Engineers Comments Regarding Surface Water Drainage

Application Reference:	WA/64/26/TDC	Reviewer Reference:	ADC/EXT5/AF
Planning Officer:	Simon Davis	Date of Review:	20/08/2026
Site Name:	Stoneybrook Farm Eastergate Lane Walberton BN18 0BA		
Application Description:	Technical Details Consent for a single self-build dwelling and detached garage following Permission in Principle application WA/79/23/PIP. This application is in CIL Zone 3 and is CIL liable (new dwelling).		
Assessment Number:	1

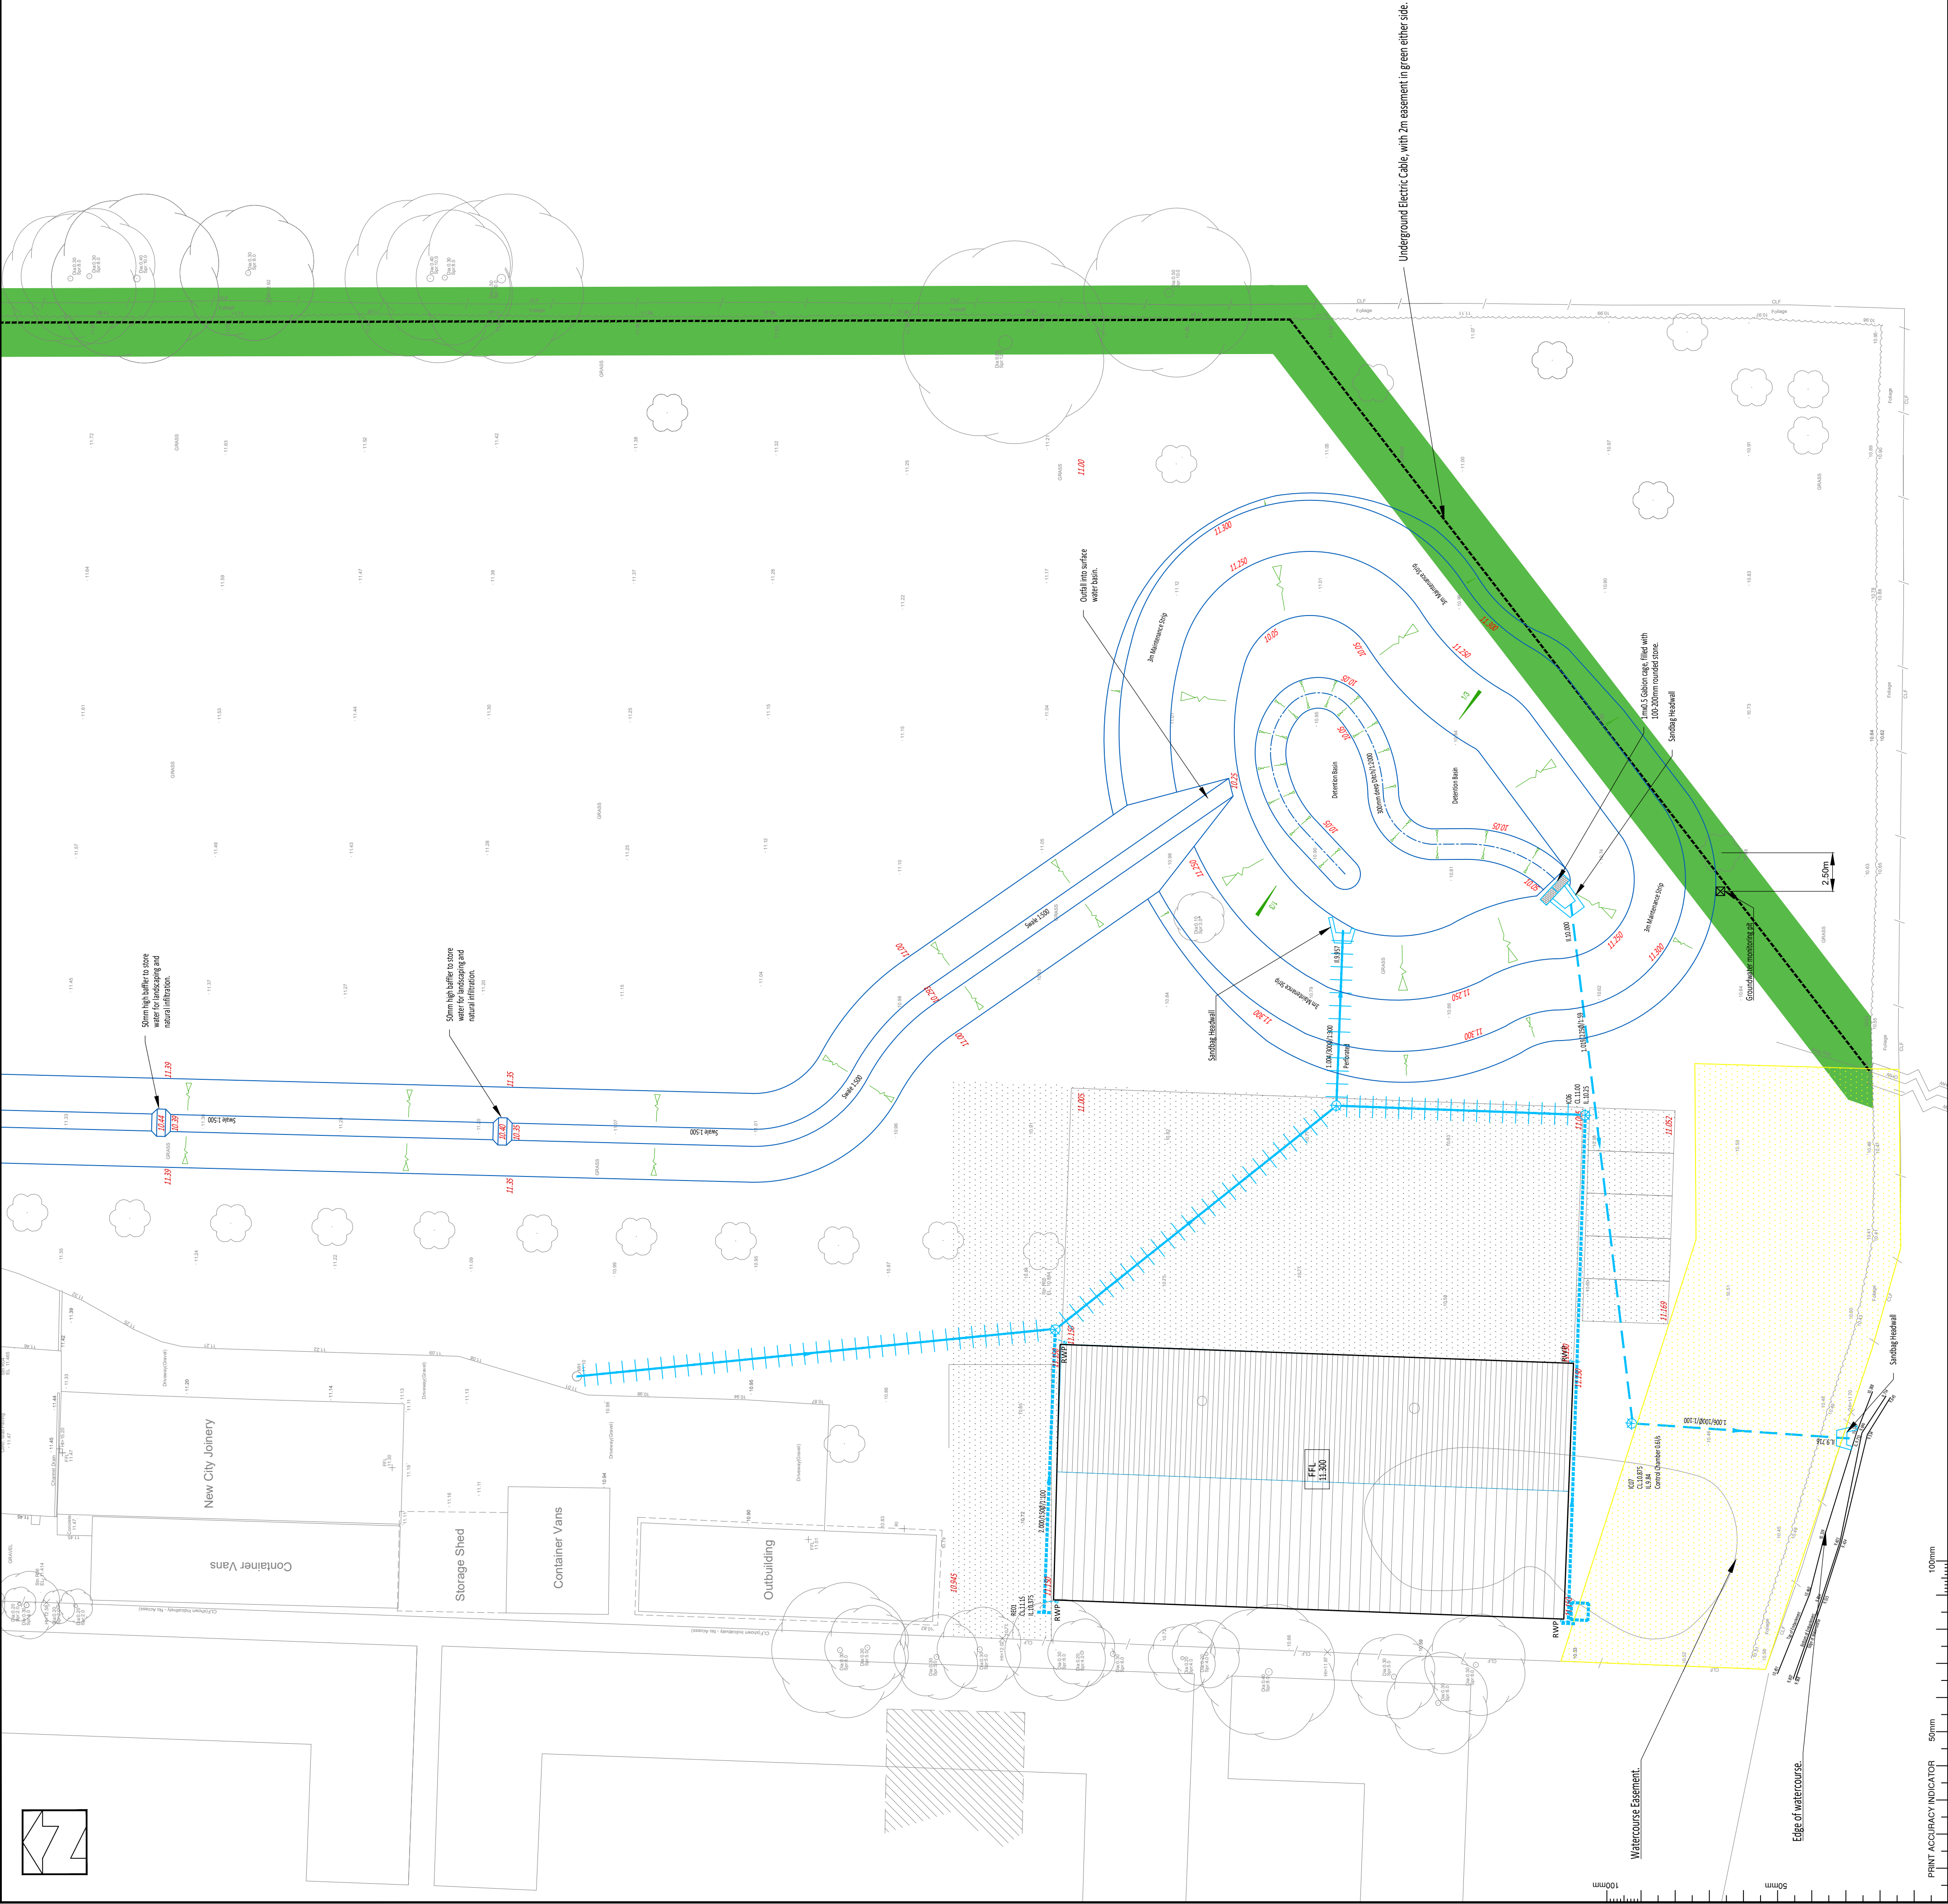
- 1.1. No rainwater harvesting provision is shown on the drainage layout plans. Plans and details of the proposed measures for reuse of rainwater should be provided as part of a technical design.

3.2. The joint drainage system needs to be assessed as a single network to ensure the combination of drainage works functions adequately and in accordance with the SuDS standards. The information provided should therefore include drained areas and drainage details for both systems to clarify the combined design. Nodes and pipe references should also be clearly shown on the drainage layout plan including any storage and flow control references.
